Ocean Gateway Addition

Wed, Apr 25, 2018 at 10:48 AM

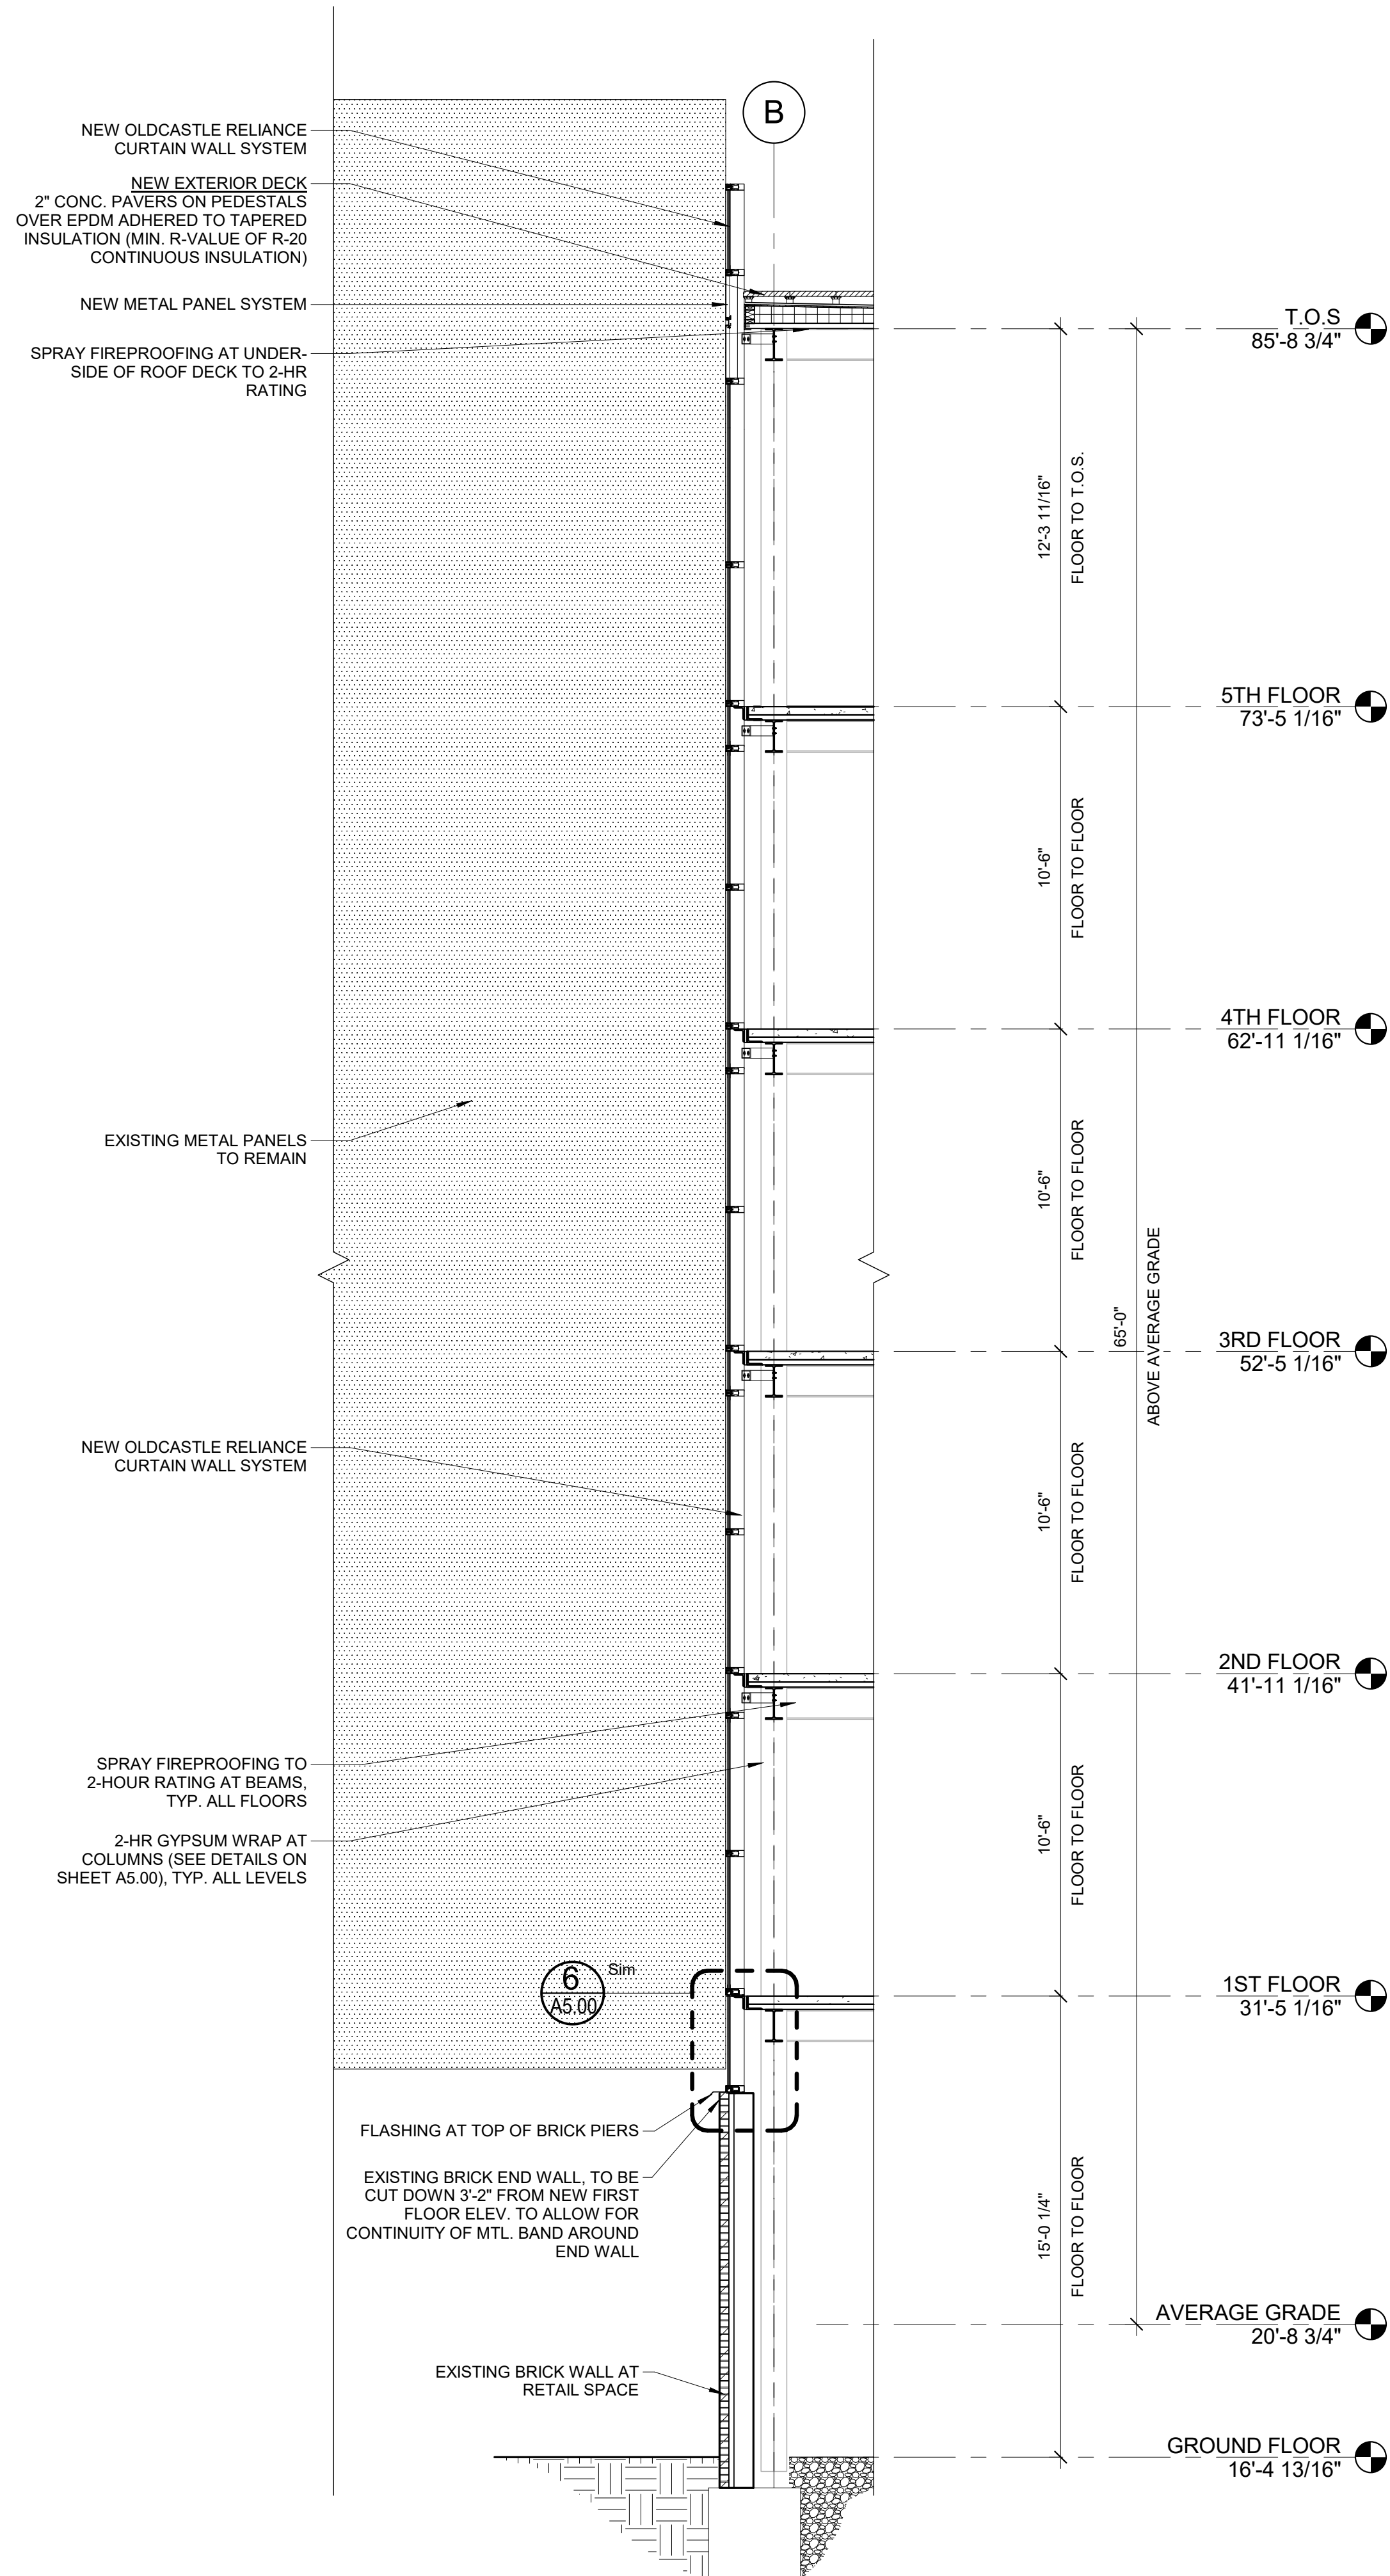
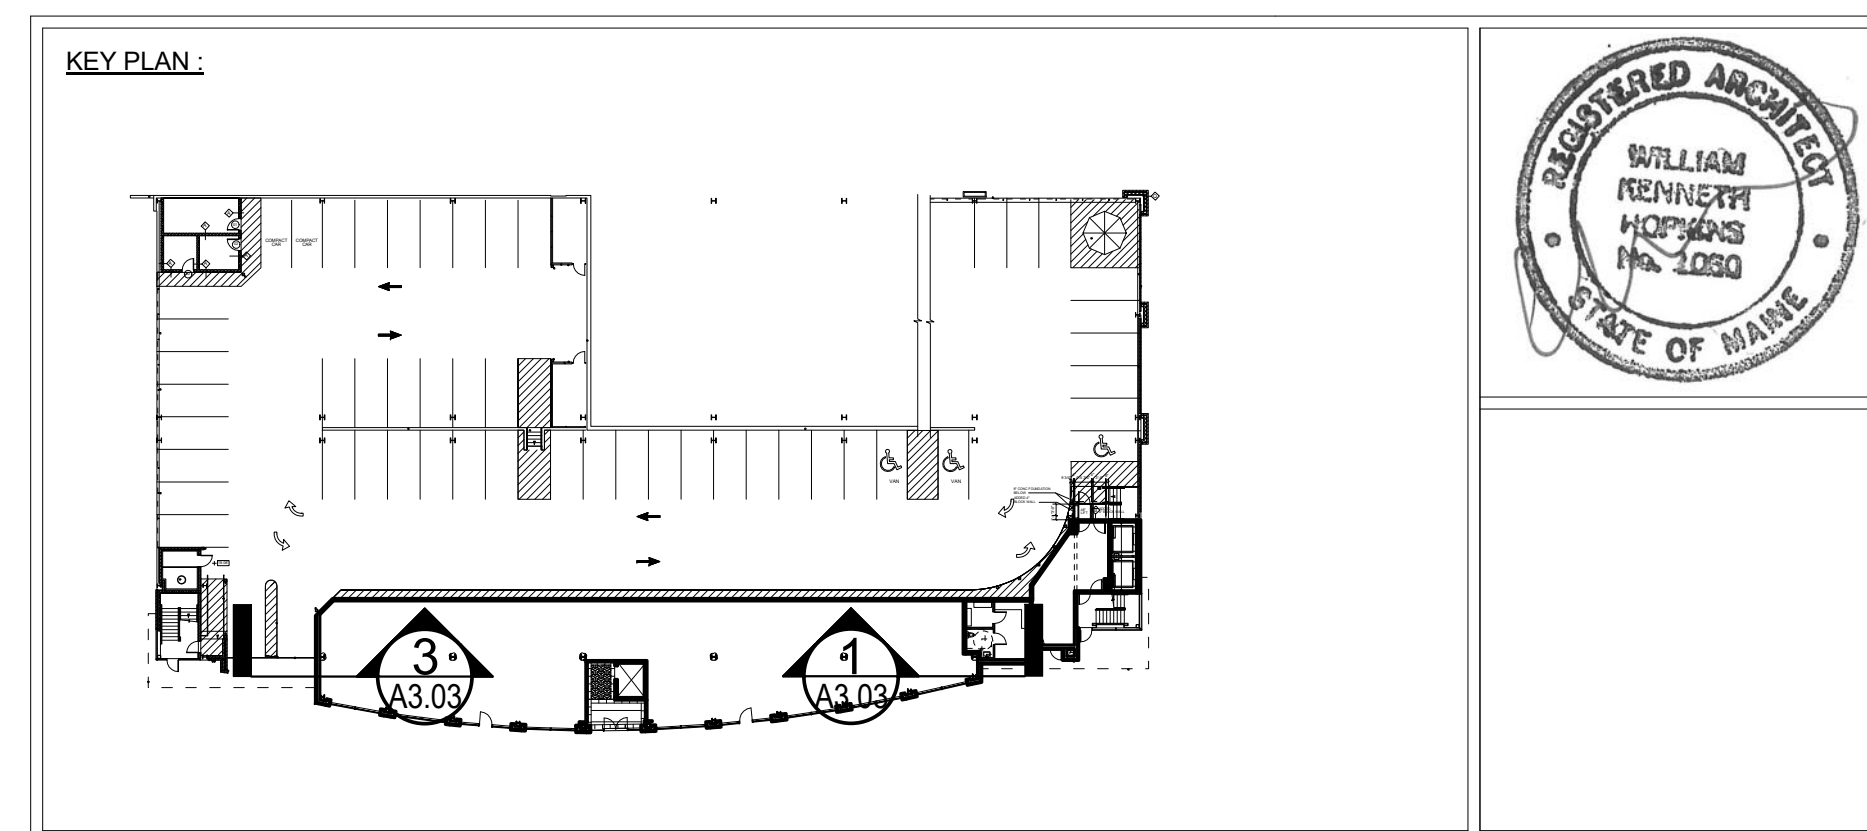
The issue is that the one means of egress from the business use also needs to be the accessible means of egress. Please note that revised plan sheets A3.02 and A3.03 also need to be submitted.

1 | GROUND FLOOR PLAN
1/8" = 1'-0"

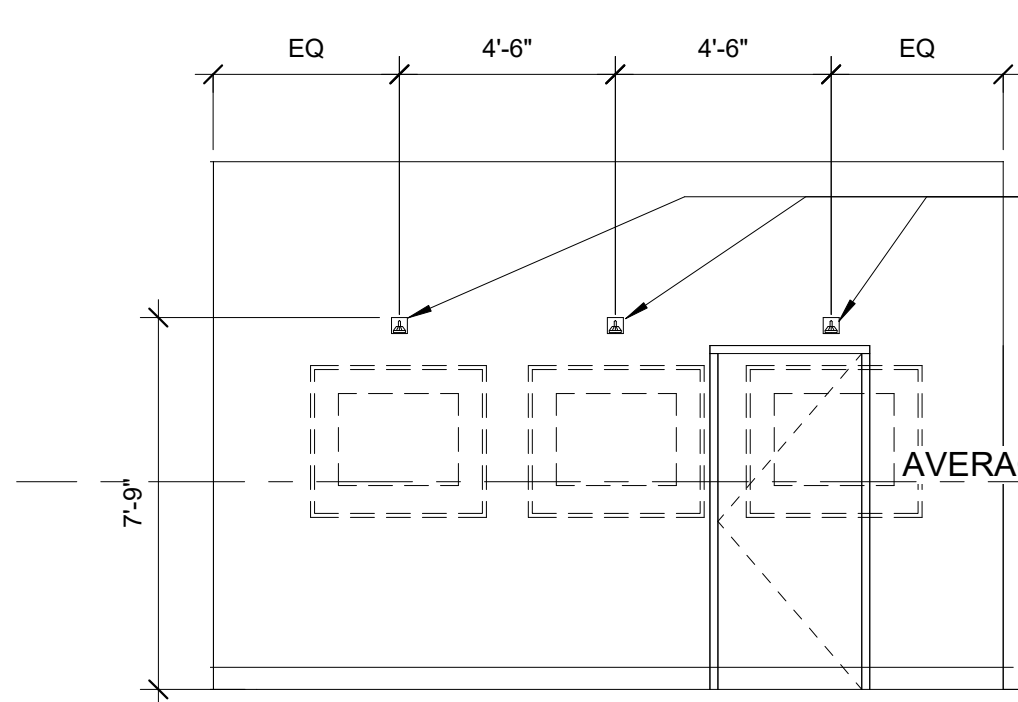
I just had the opportunity to look at the proposed as built plans and notice that the access to this corridor is via steps and a landing. This does not comply with Sec. 1007.1 Accessible means of egress for this business use addition. The original plans utilizing the left hand stair did not show a change in elevation from the office to enclosed egress.

Please take a look at this and provide a means to correct this issue.

I attached the plans and details that were part of the original submission. These plans, which were approved, did show the elevation change in the enclosed egress corridor.

Per section 1007.1 we are required to have 1 accessible means of egress. Our plans call out for an accessible means of egress located adjacent to the elevator at each floor. The egress corridor to the stair tower is our second means of egress for the addition space.

1 FIRST FLOOR PLAN
1/8" = 1'-0"

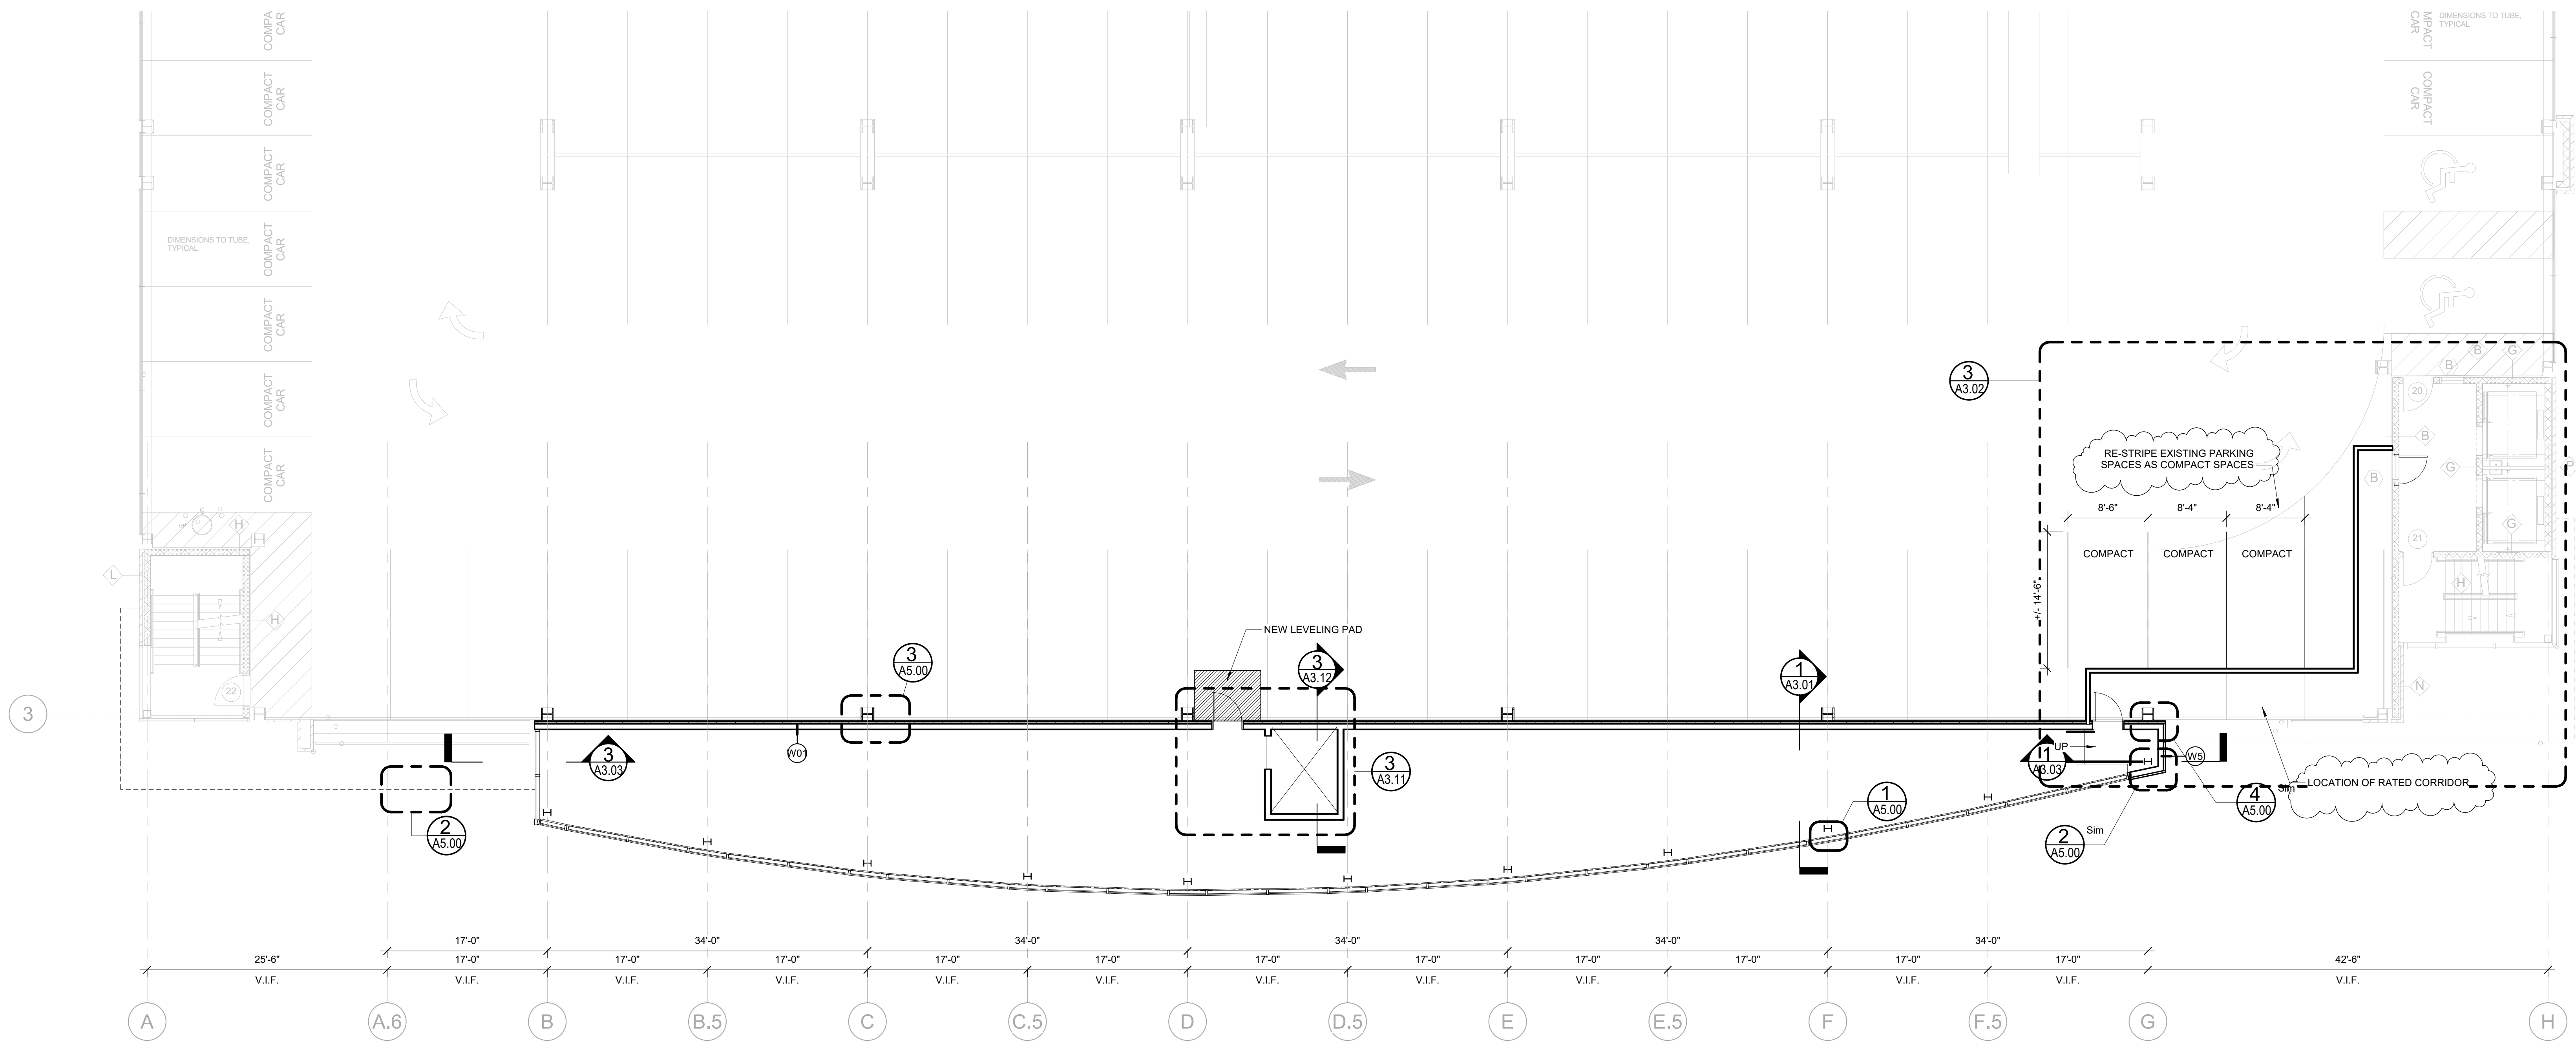
We referenced the approved plans and noted that the enclosed egress path was to the exit stair tower on the left not the right, therefore, this is a substantial change from the approved plans.

In terms of amending the permit, I do have a question. On the floor plans we submitted for permit (see attached) we had called out this location as an alternate for the corridor as it was going to depend on the clearances we could achieve in connecting to the existing garage. I did know if this was enough to own this scope of work as part of the original permit so we didn't have to amend it.

In lieu of an amendment, we will view this as an "As Built" change. Please send me a complete floor plan set with the change showing the enclosure on the right side and removed from the left. I will file these with the approved documents.

Thanks Michael, I have filed the as built plans for the relocation of the rated exit access corridor to the opposite side (right side front face) with the permit files.
